BUSHFIRESAFE (AUST) PTY LTD

Our Ref: 6106/2010

Tuesday, 16 February 2010

**RE: Community Title Subdivision & Construction of 32 Dwellings for Lot 211
DP1044292 & Lot 1 DP262300 Pacific Highway, Moonee:**

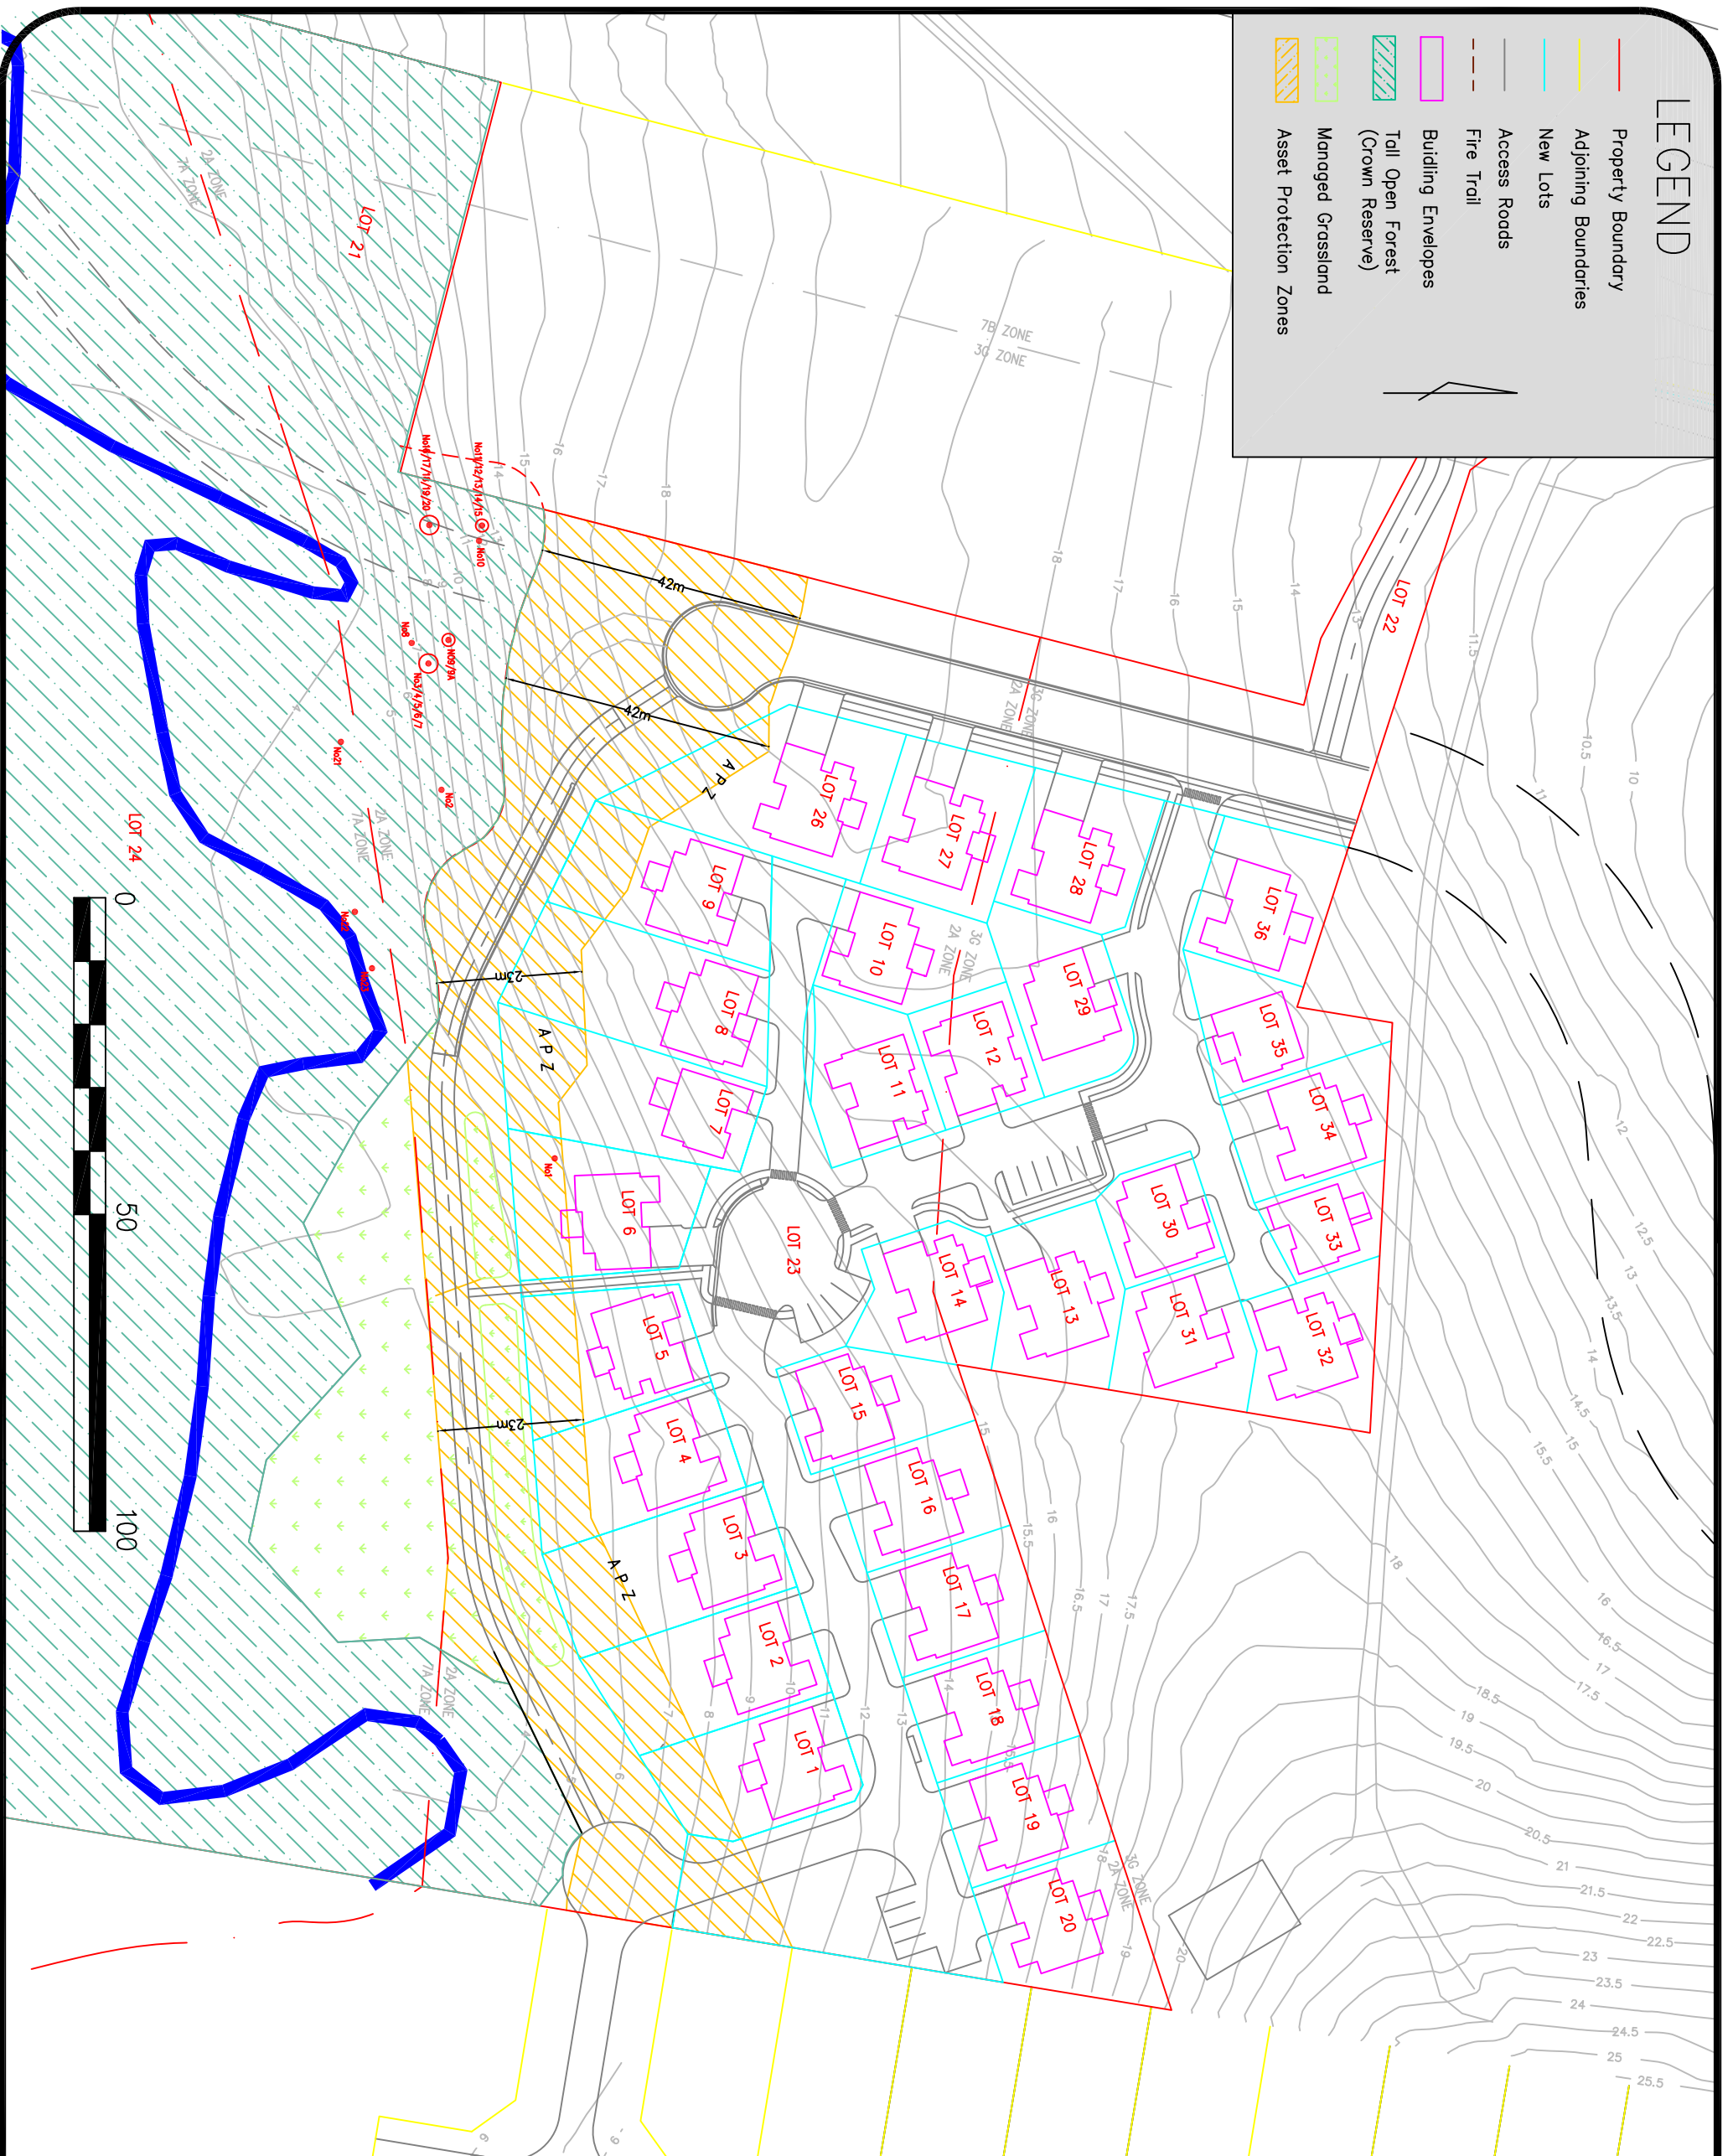
2) *A part of the proposed APZ falls in the 7(a) Environmental Protection Zone. The EA should justify whether having an APZ in this zone complies with the objects of this zone and whether it is a permissible use.*

Comment: As part of the development and the dedication of the 7(a) Environmental Protection Zone to Council the part of the APZ that falls within the 7(a) Zone is to be maintained by Council's village maintenance program, which is identified within the Bushfire Risk Management Report prepared by (Bushfiresafe (Aust) March 2007) Section 5.1 pages 9 & 10. An extract of pages 9 & 10 of the Bushfire Risk Management Report is found below:

As part of the development, a large portion of the 7(a) Environmental Protection Catchment and Habitat shall be dedicated to council; the portion of the recommended APZ that occurs within the dedicated land shall be maintained by council's village maintenance program.
